**REQUEST**

Current Zoning: ML-1 (Manufacturing & Logistics 1), ML-2 (Manufacturing & Logistics 2), and N1-B (Neighborhood 1-B)  
Proposed Zoning: I-2 (CD) (General Industrial, Conditional)

Approximately 5.86 acres located on the east side of China Grove Church Road, south of Westinghouse Boulevard, and north of Blu Rail Way.

The petition proposes to allow all uses permitted in the I-2 zoning district as well as outdoor storage, trucking operations, trucking repair and maintenance, office, and storage of trailers.

**SITE PLAN**

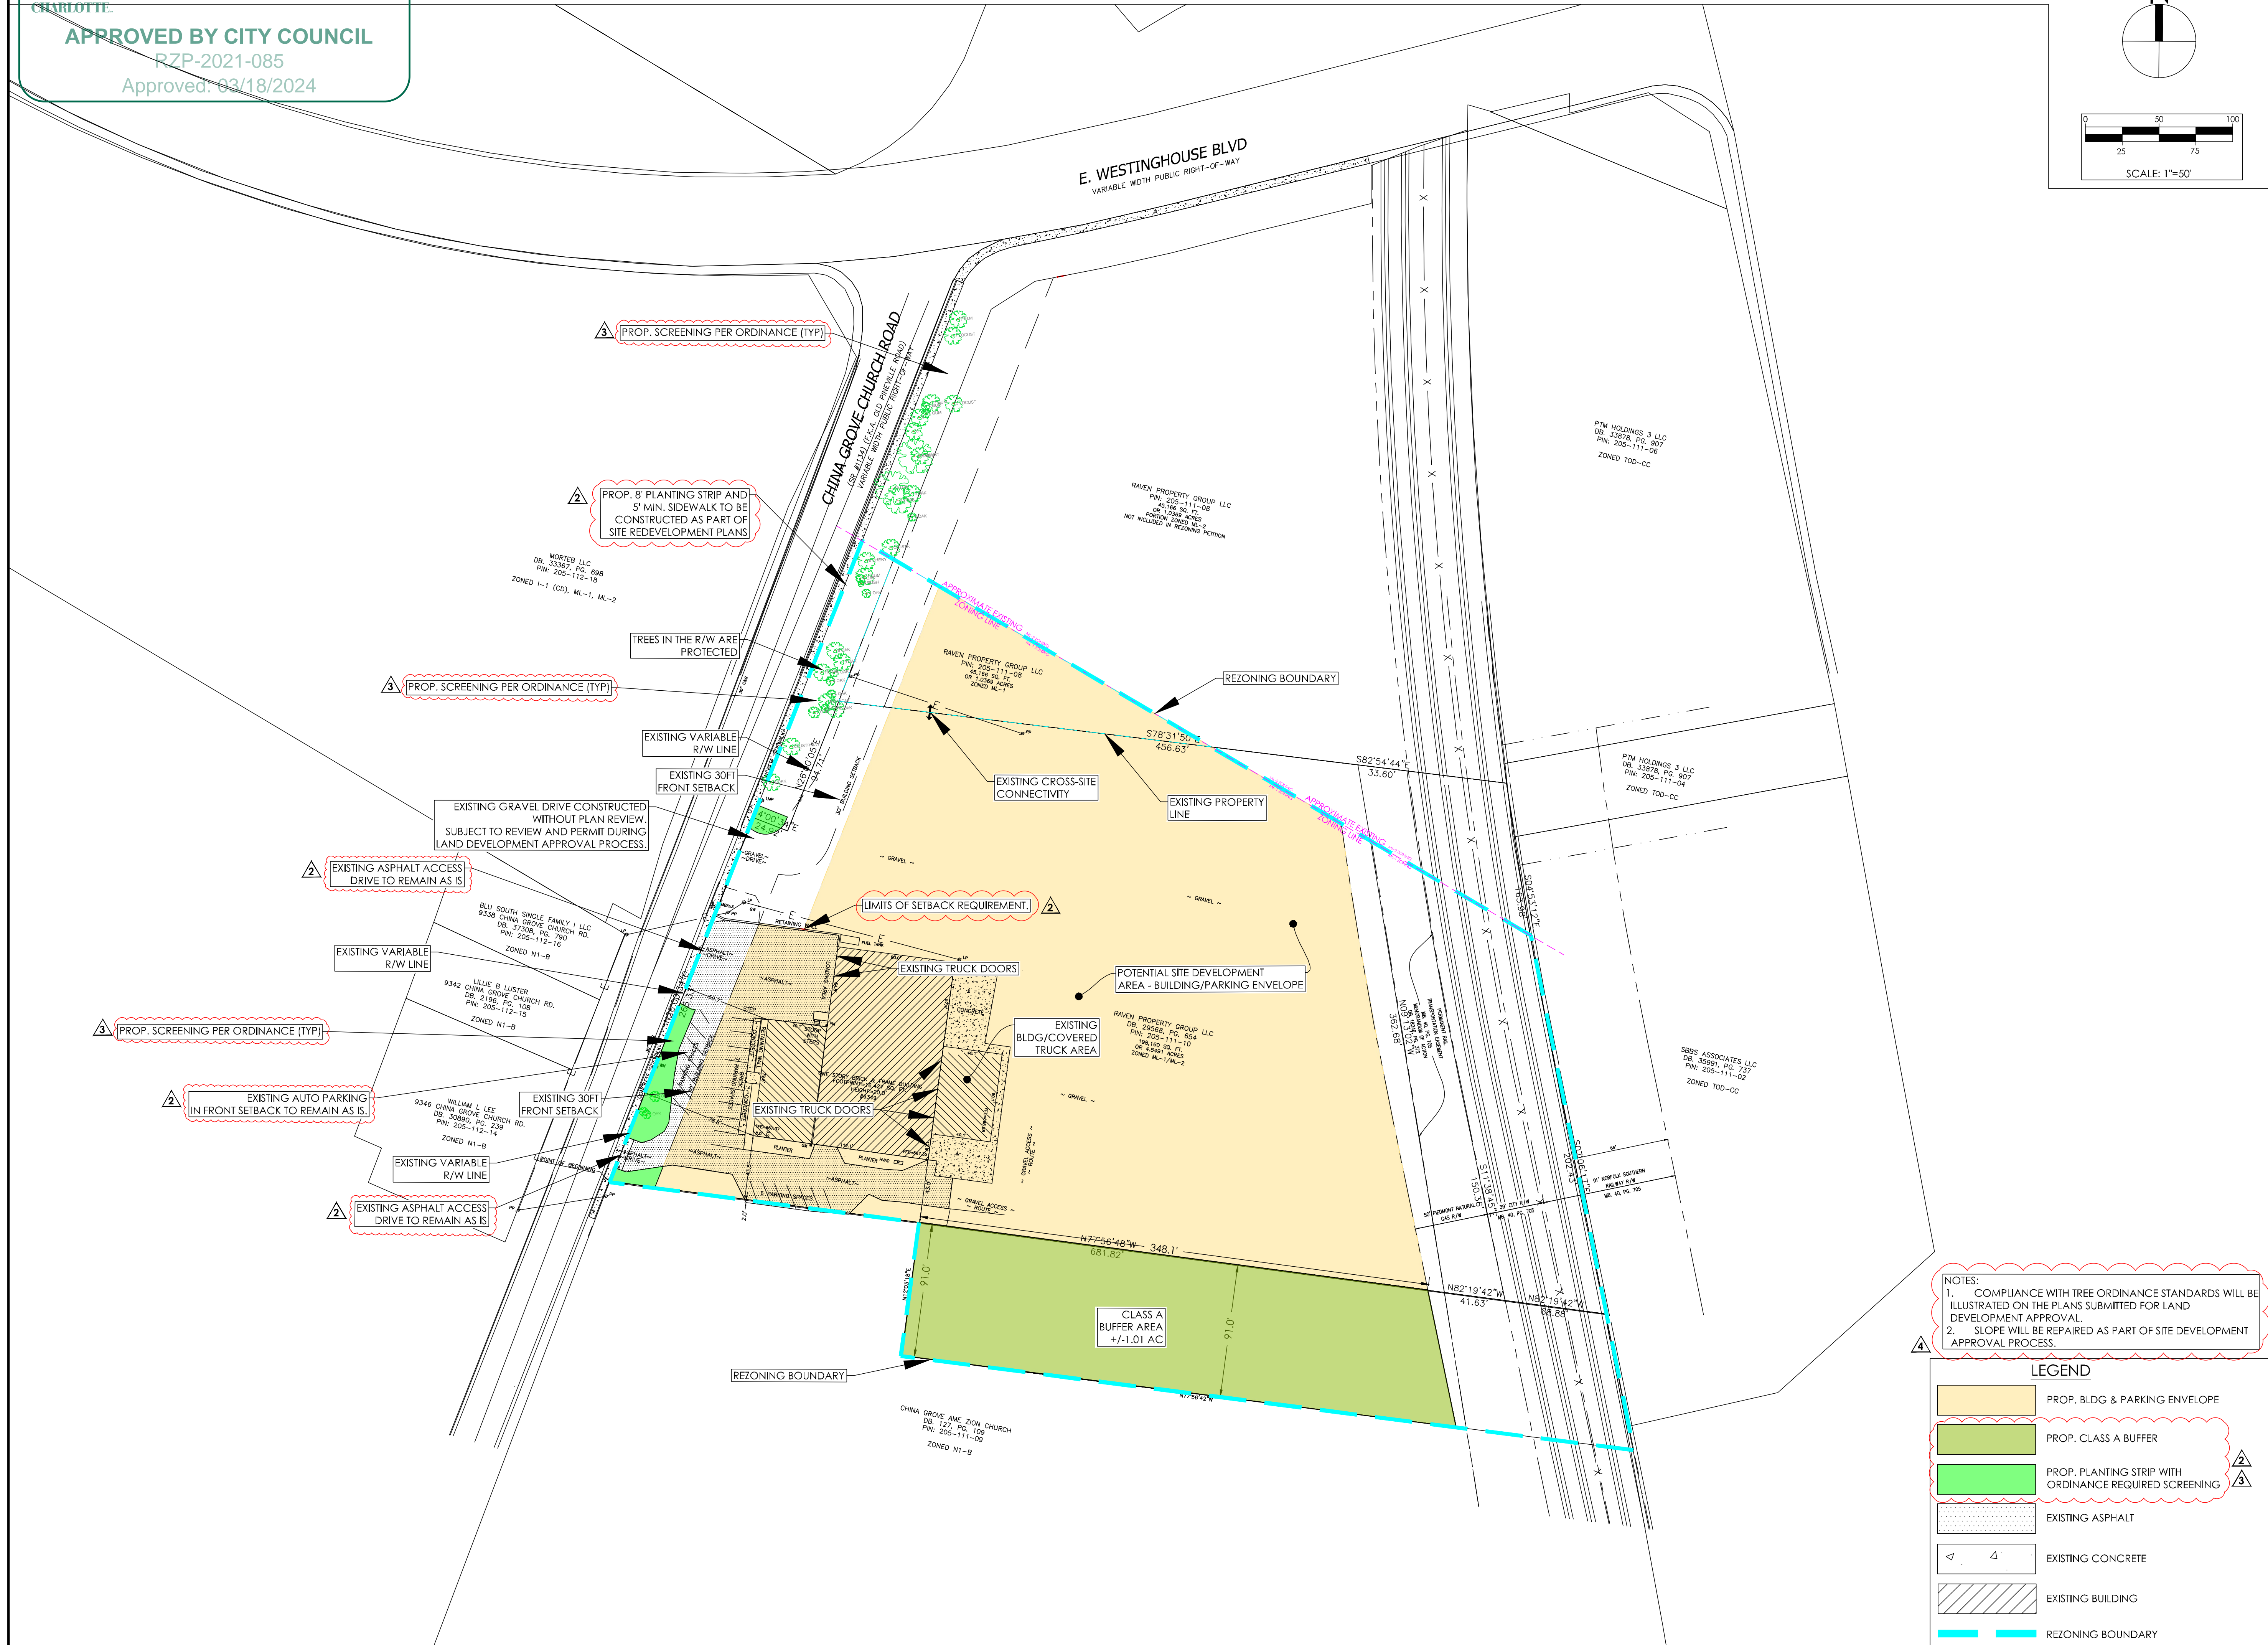
1. ~~Provide a tree survey identifying all trees of eight inch DBH or greater and all planted trees of two inch caliper or greater and six feet in height that grow partially or wholly within public street right-of-way. The survey shall also identify all trees of eight inch dbh or greater within the tree protection zone.~~ **ADDRESSED**
  2. Remove parking area and driveway in the southwestern corner of the site and plant buffer. **OUTSTANDING**
  3. ~~Illustrate ordinance required screening along China Grove Church Road on the site plan.~~ **RESCINDED**
-
